Ref. EP/47/19/HH site 11 Michel Grove, East Preston BN16 2SX.

I wish to make an objection to the above application.

Proposed Elevations
1:100

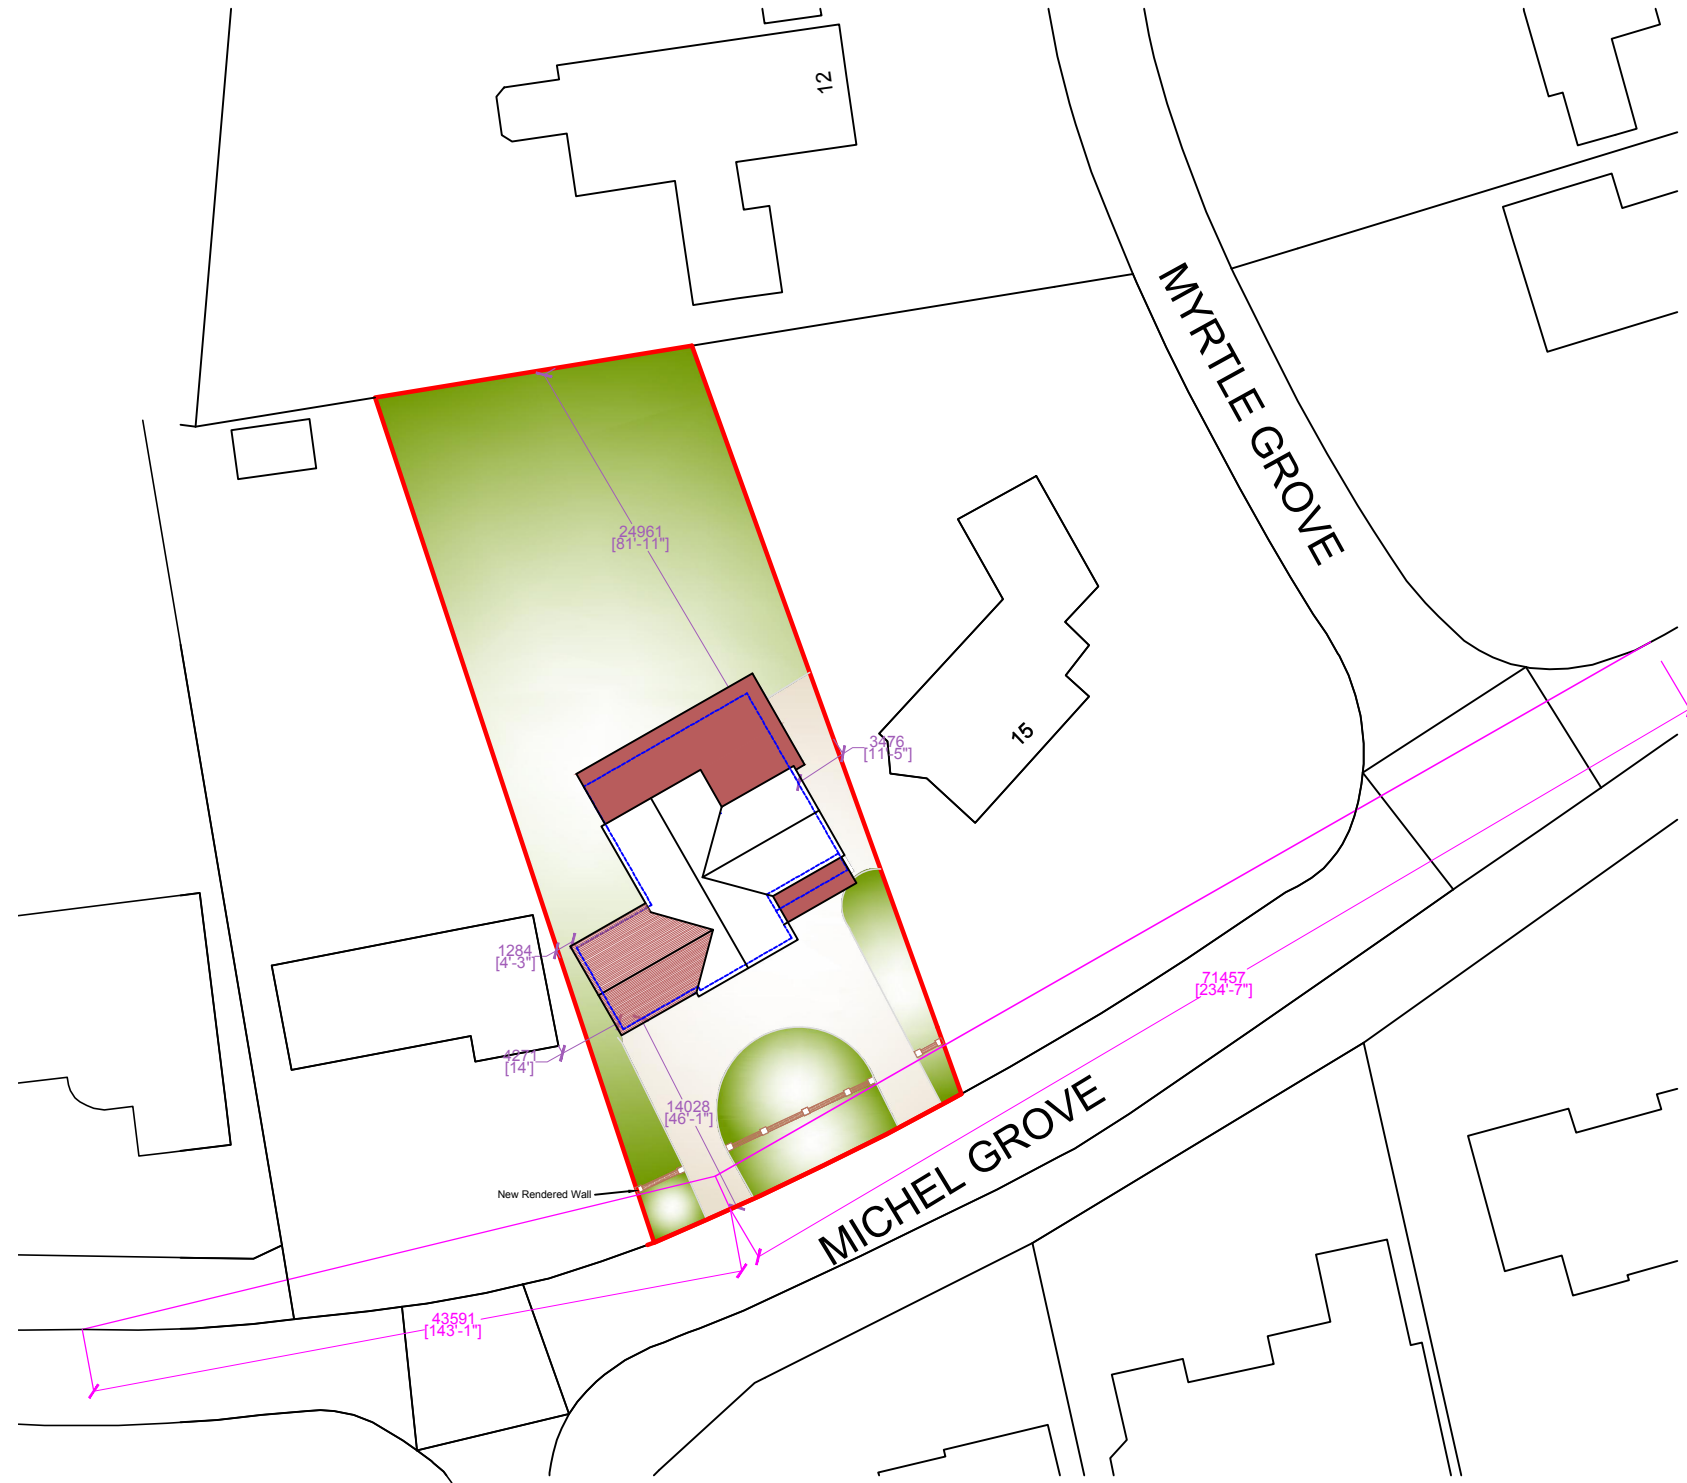
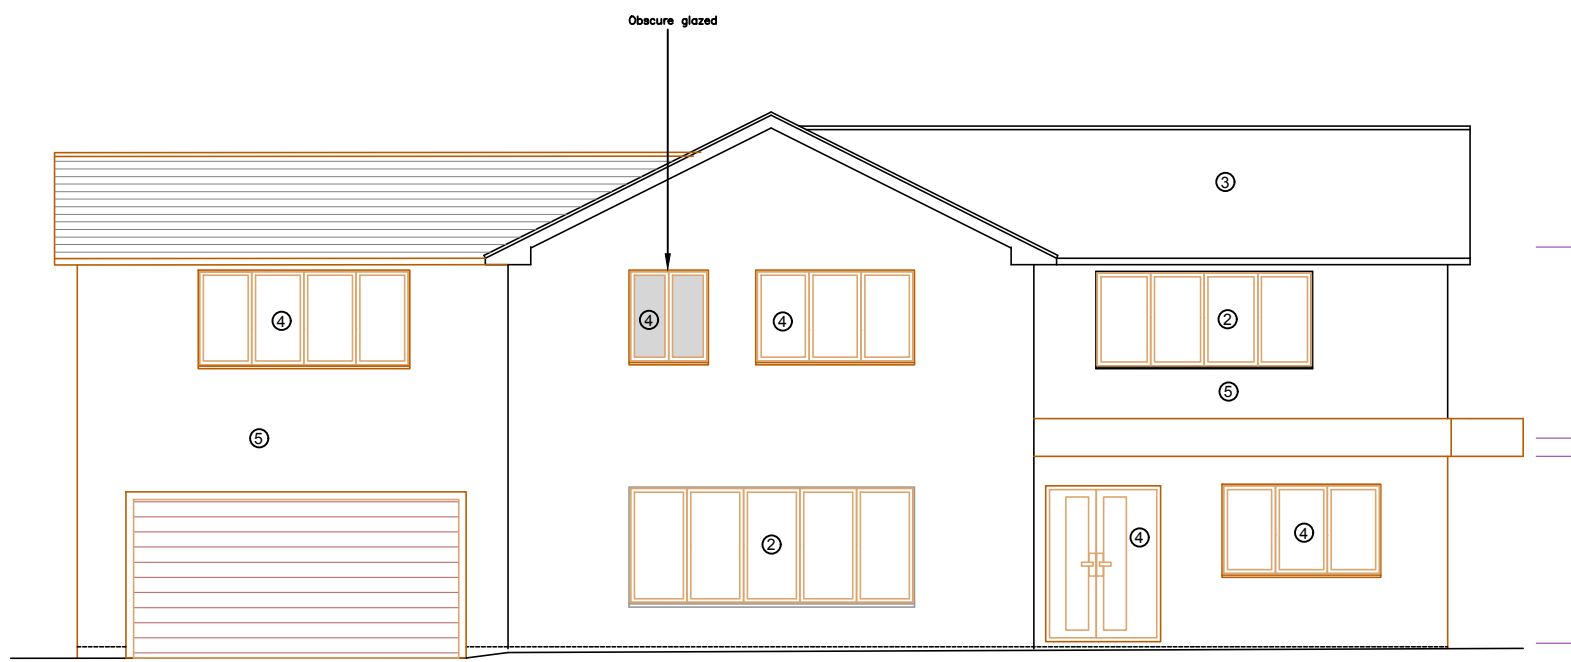
Although small alterations have been made to the original application there has been no attempt to deal with the above policies and as such this application should be refused. The insubstantial alterations made to the application to deal with the overlooking aspect are of a temporary nature and can be changed back at any time in the future.

Street Scene
1:100

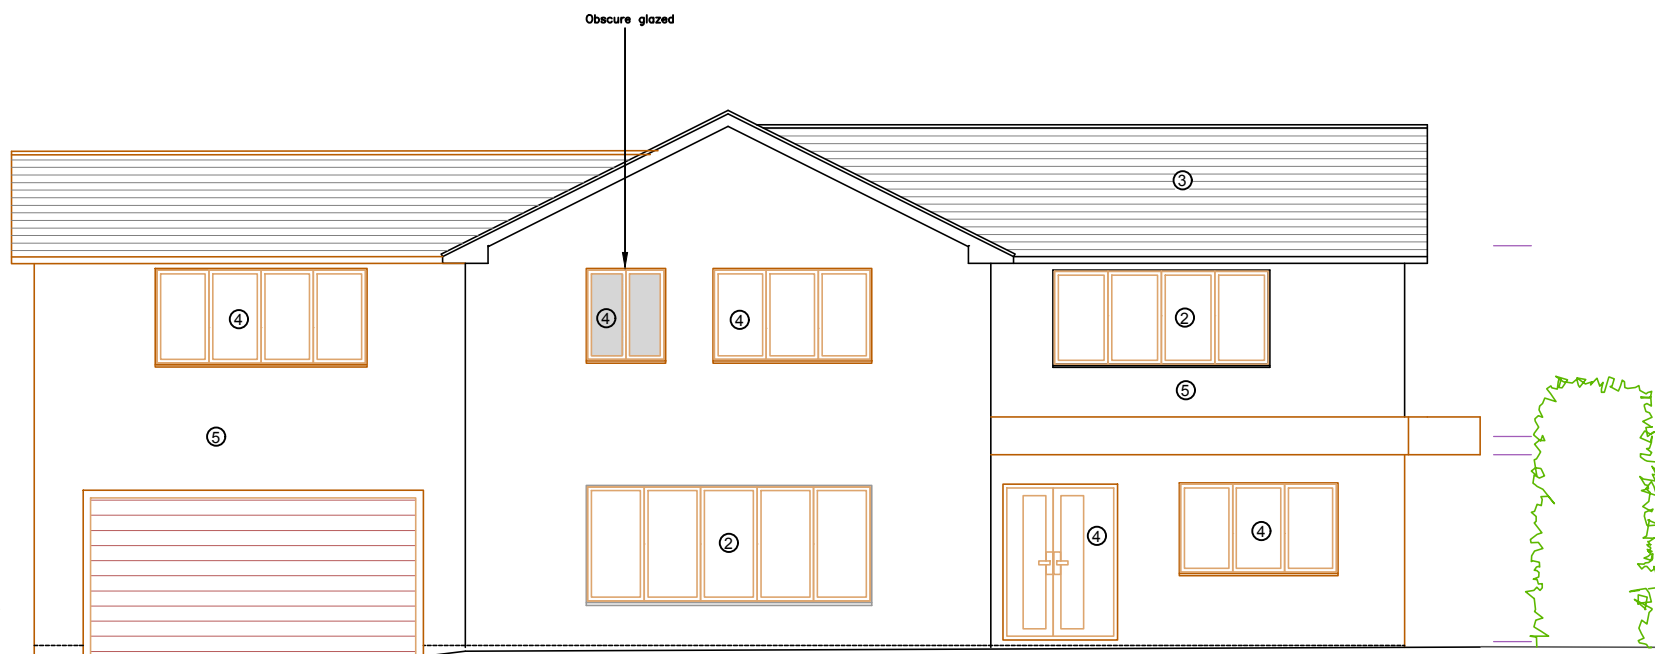
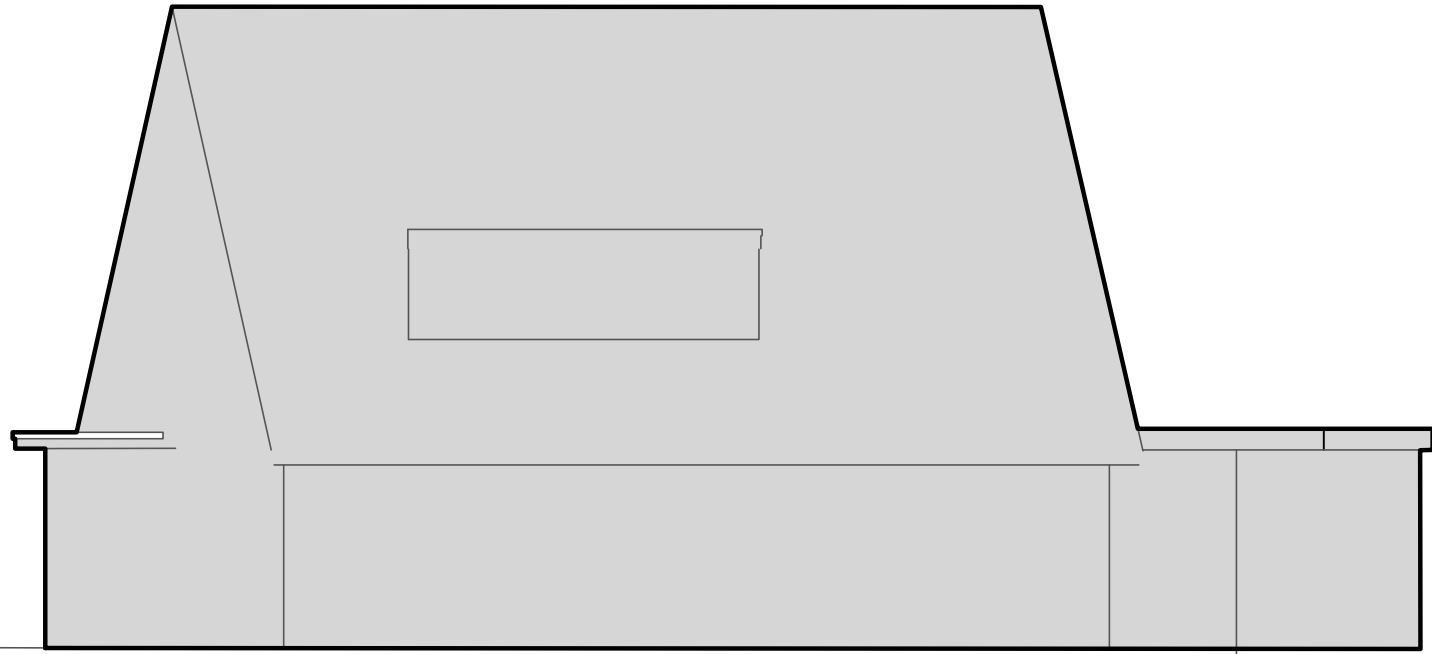
In this new application a street scene has been added, which can only be described as incorrect, and designed to mislead. Attached you will find a Google Earth plan with the applicant's proposal superimposed over it. The street scene will be that of a pair of semidetached houses. I also attach a photograph of the site taken from the ground level of the street with the proposed alterations layered over it. This photo has been adjusted to be presented at the same scale of the submitted architect drawings. Unlike the applicant's street scene, you will see that there is no clear space between the two properties but the applicant's extension will overlap number 9. The applicant's positioning of number 9 on their submitted drawings is incorrect (as presented as a black outline on the photo) Our street scene is correct (with the actual structure of number 9 clearly visible on the photo) and I will explain any technical questions that you may have.

It is disappointing and frustrating that even in this second application, (following the first refusal) the applicant and their advisors have still not managed to submit a more credible effort to illustrate the “actual street view” of this development and the impact it actually has to the surrounding environment.
